Reference: East Northants Resource Management Facility Western Extension

The Woodland Trust **objects** to this proposal on account of likely deterioration and detrimental impact to Collyweston Great Wood, an Ancient Semi Natural Woodland designated on Natural England's Ancient Woodland Inventory (AWI) which forms part of both Collyweston Great Wood and Easton Hornstocks Site of Special Scientific Interest (SSSI) and National Nature Reserve (NNR).

Figure ESA5.1 Scale: 1:2,500@A2

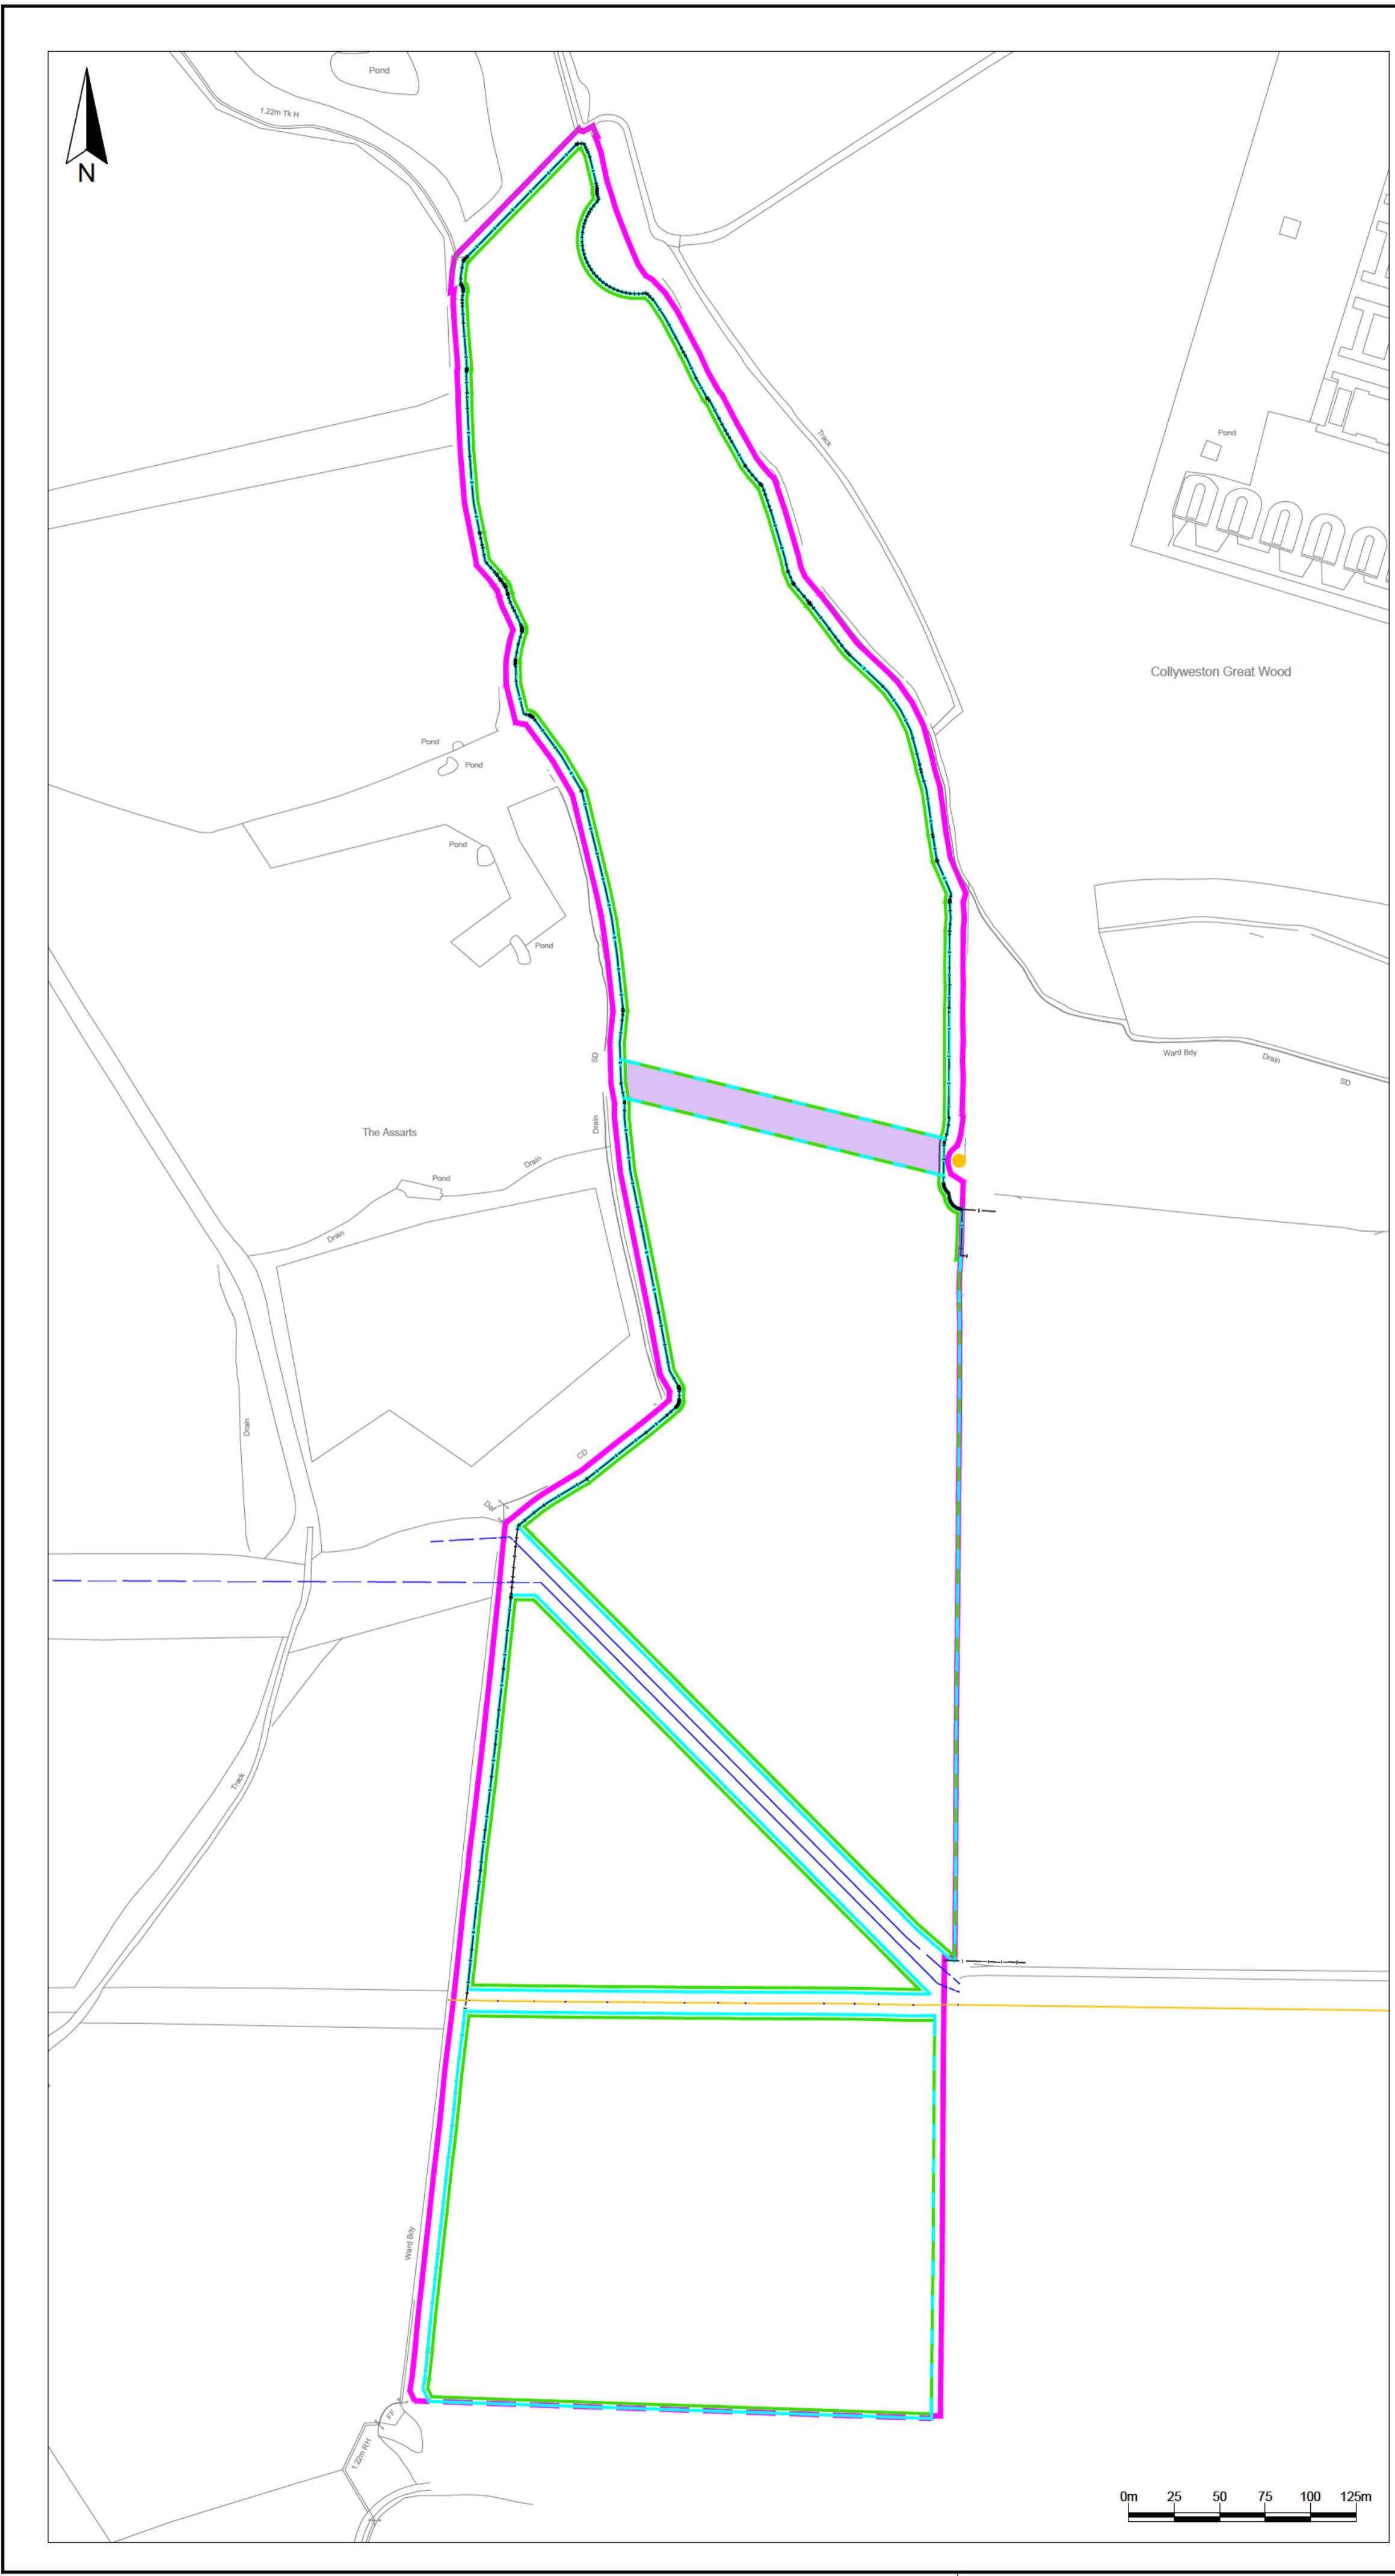
With respect to the proposed quarrying/landfilling works, a buffer zone of at least **100 metres** should be afforded to allow for the potentially significant impacts of dust pollution generated from the development. Regarding the waste treatment and recovery facility, a buffer zone of **at least 30 metres** should be provided to prevent adverse impacts such as pollution and disturbance and ensure avoidance of root damage.

The buffer should be planted before construction commences on site. HERAS fencing fitted with acoustic and dust screening measures should also be put in place during construction to ensure that the buffer zone does not suffer from encroachment of construction vehicles/stockpiles, and to limit the effects of other indirect impacts.

The Trust **objects** to this proposal on the basis of indirect impacts to ancient woodland. The applicant should seek to afford suitable buffer zones to ensure protection for Collyweston Great Wood. Where appropriate mitigation is not achievable then the application should not be taken forward.
